Your ref: SSD-5544-Mod-7
Our ref: DOC25/556747

Subject: Request for Advice on Modification 7 – Infrastructure consolidation and remediation (SSD-5544-Mod-7) (Sutherland Shire)

CPHR comments on Modification 7 Infrastructure consolidation and remediation (SSD- 5544- Mod-7) (Sutherland Shire)

**FIGURE F3:
FIRE WATER SYSTEM AND
OILY WATER SEWER**

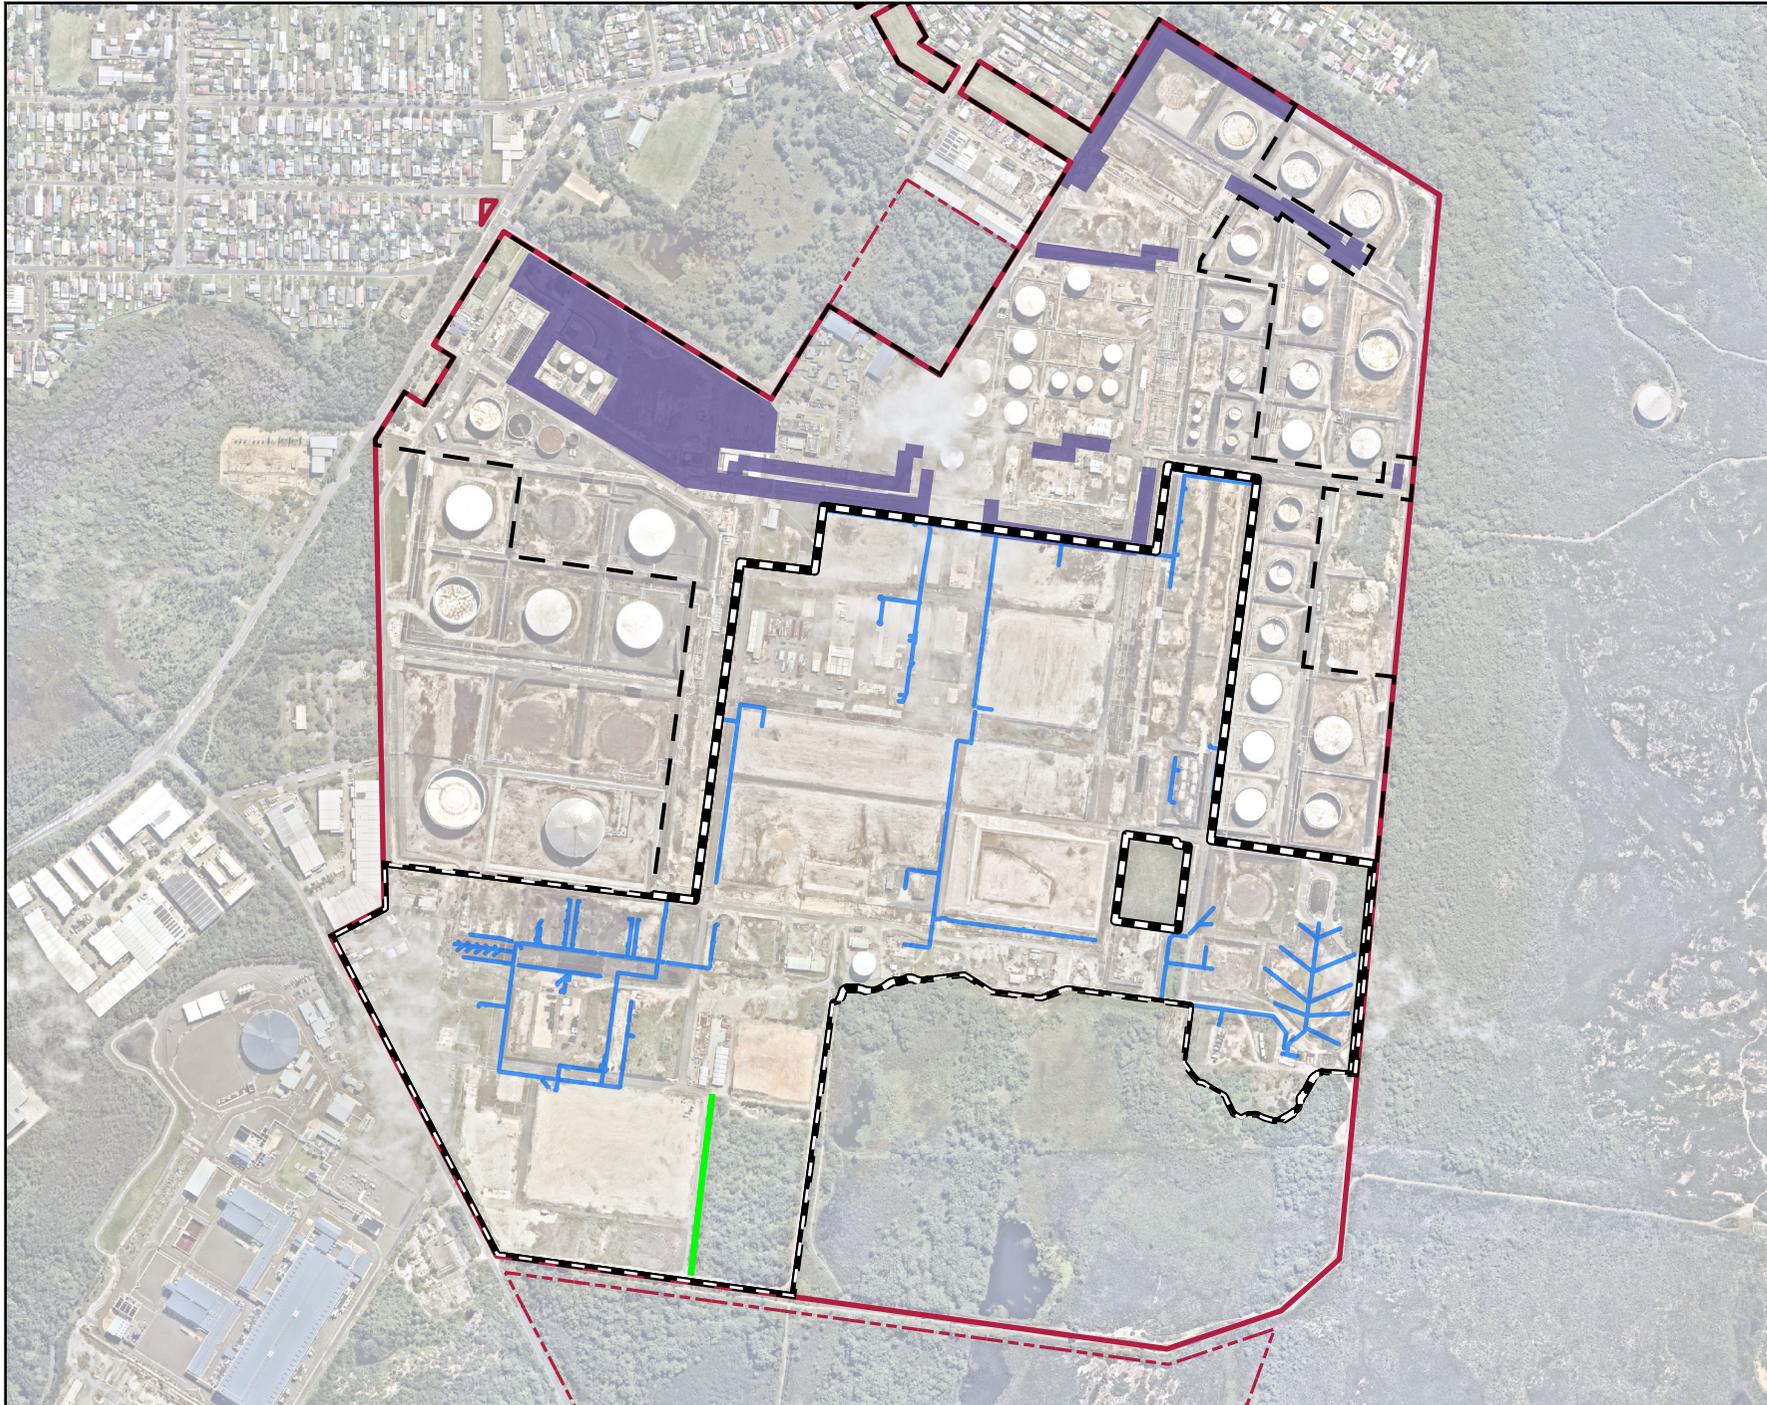
20.	<i>Site management does not provide adequate separation of clean and dirty water flows</i>	The site has separate OWS and SWS, however, no evidence is provided on the management of off-site flows. The site's catchment extends to the ridgeline of the adjacent Kamay Botany Bay National Park. The rear section of the site and the national park are very steep and have rapid runoff rates that would have erosive velocities. Allowing these flows to enter and pass across the site without appropriate management controls increases the volume of water passing over unstable or potentially contaminated surfaces. This places additional stress on the site's stormwater management system and increases the potential for pollution events. Recommended action: • Develop a strategy to manage off-site flows to reduce stress to on-site systems and reduce pollution management requirements.
	<i>Extent and Timing</i>	Prior to Response to Submissions.
